CITY OF ALBUQUERQUE

February 8, 2017

**Re: Galles Chevrolet
Erosion and Sediment Control Plan
Engineer's Stamp Date 1-3-17 (H15E065)**

EROSION
AND
SEDIMENT
CONTROL
PLAN
ESC 101

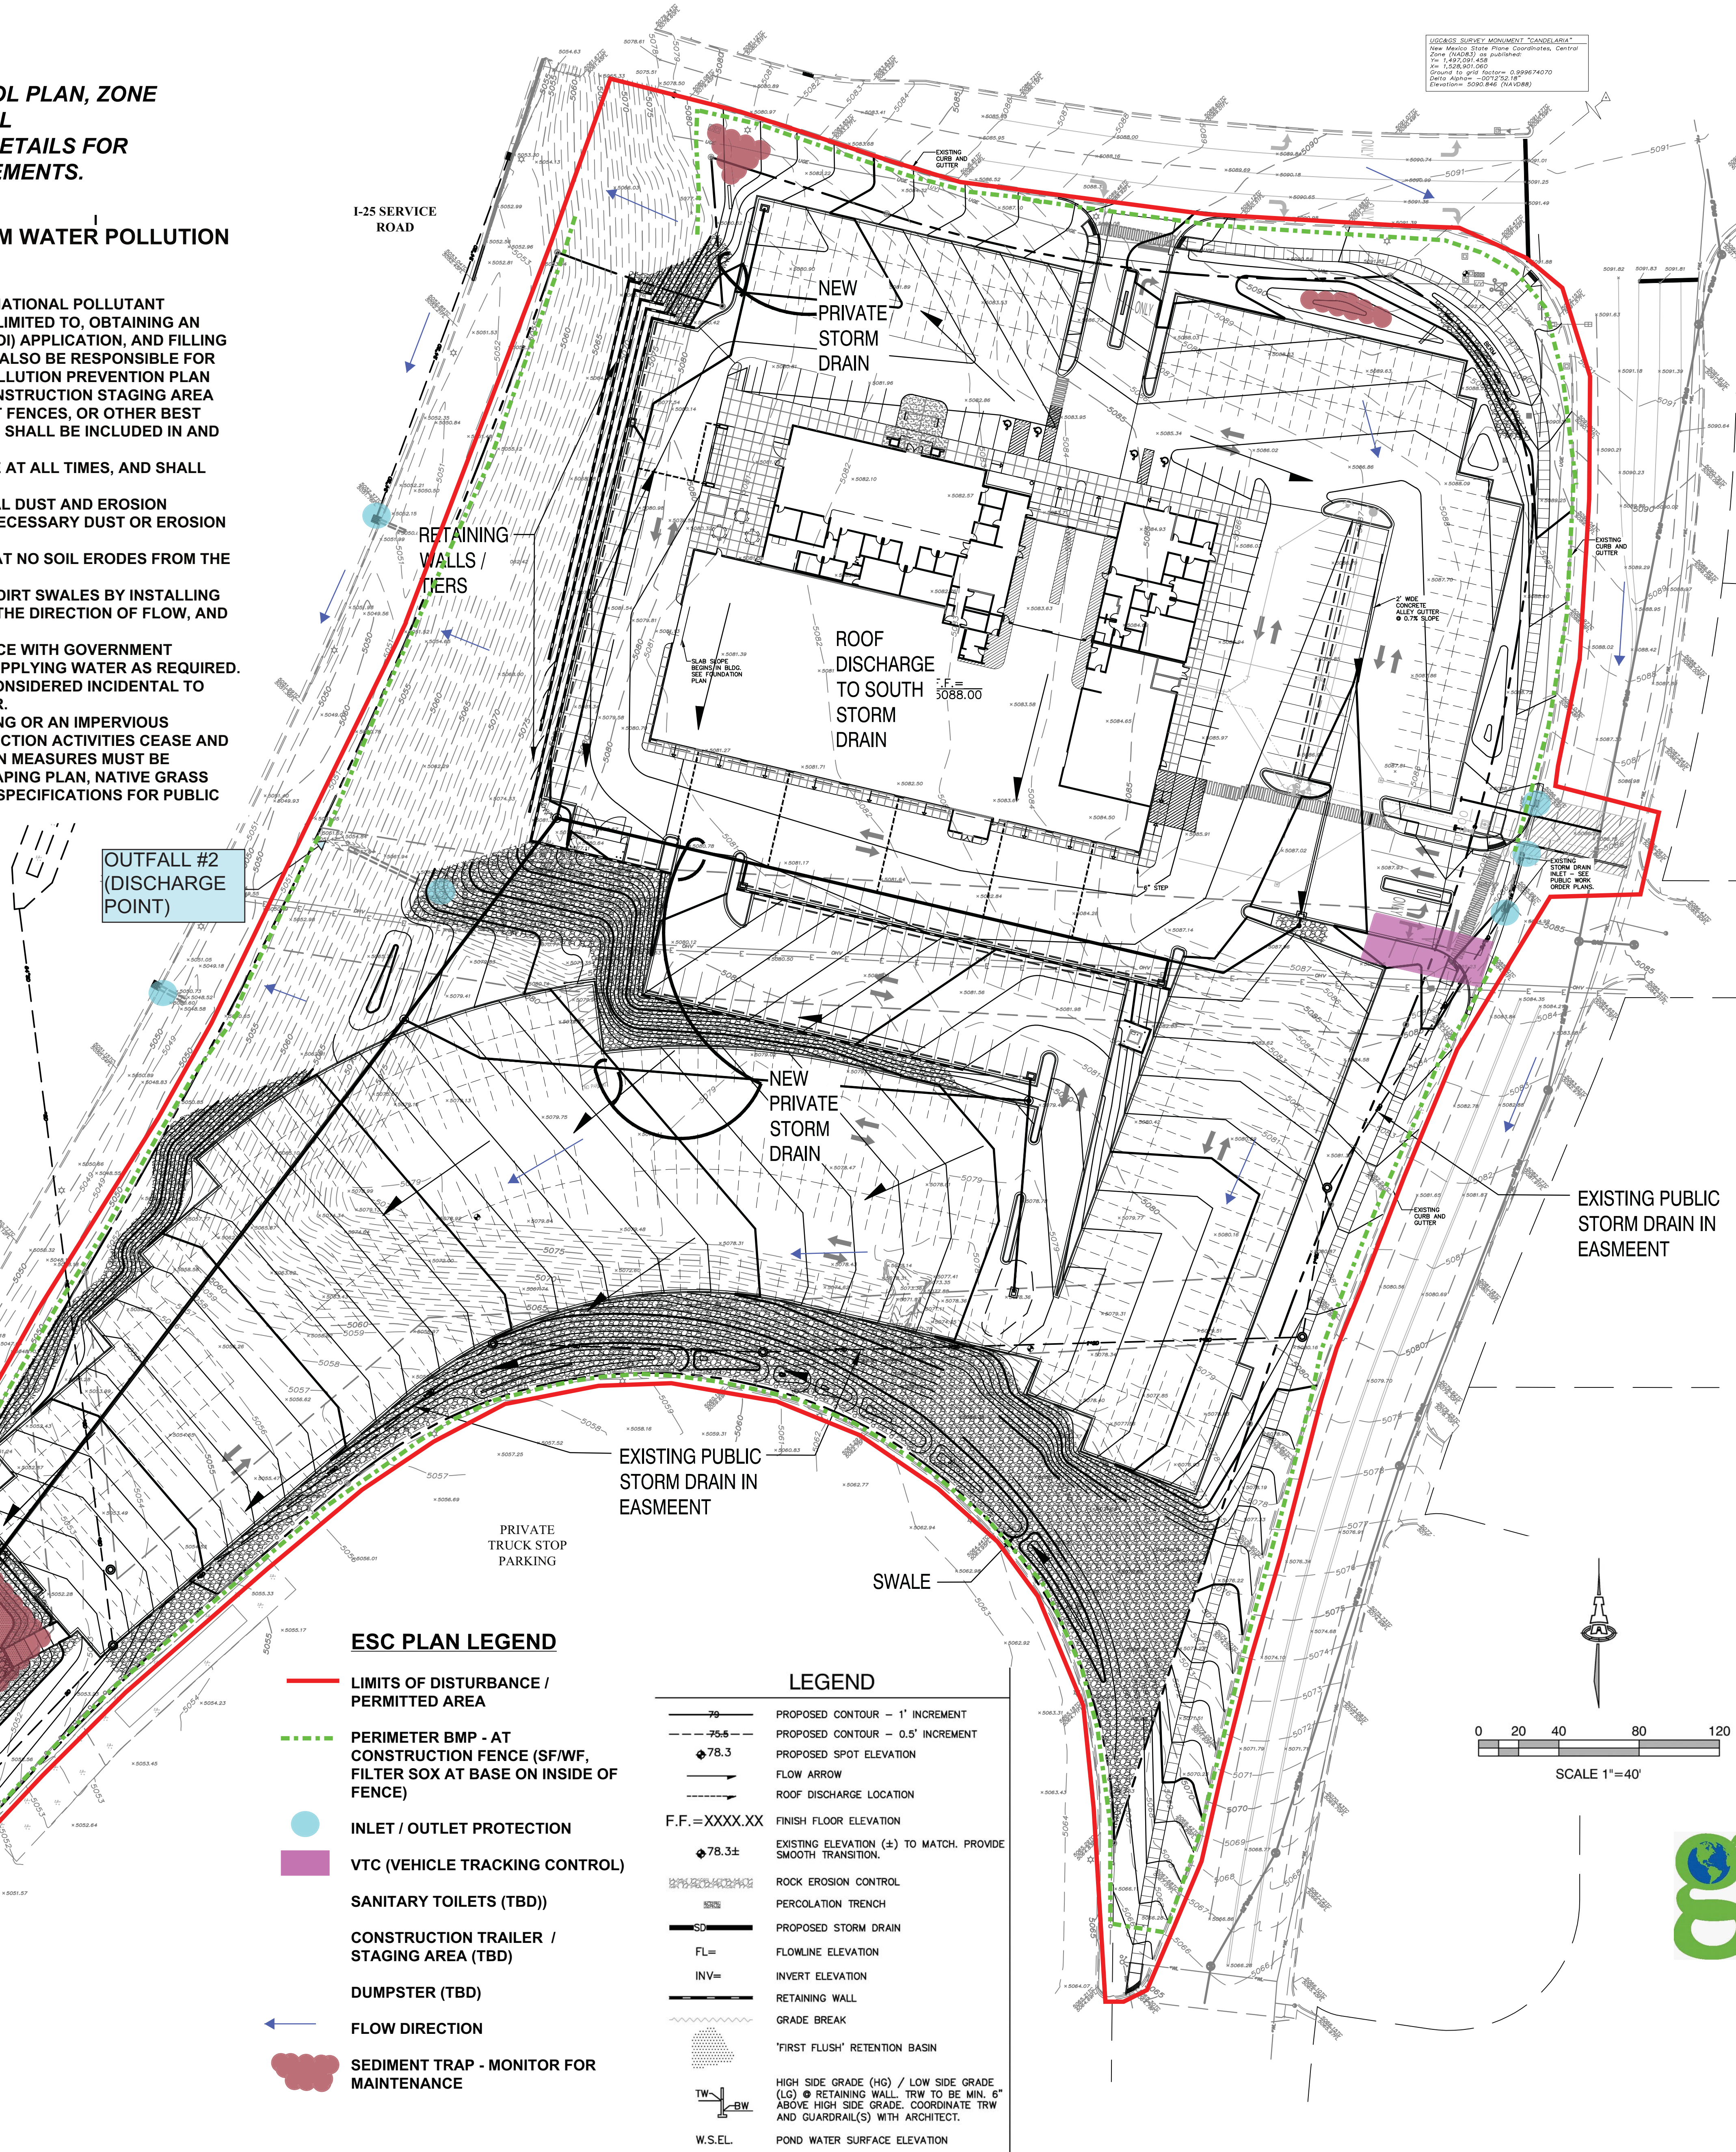
Please consider straw wattles or similar erosion protection on the slopes in the southwest area and grading the pond in the southwest corner early in the development process.
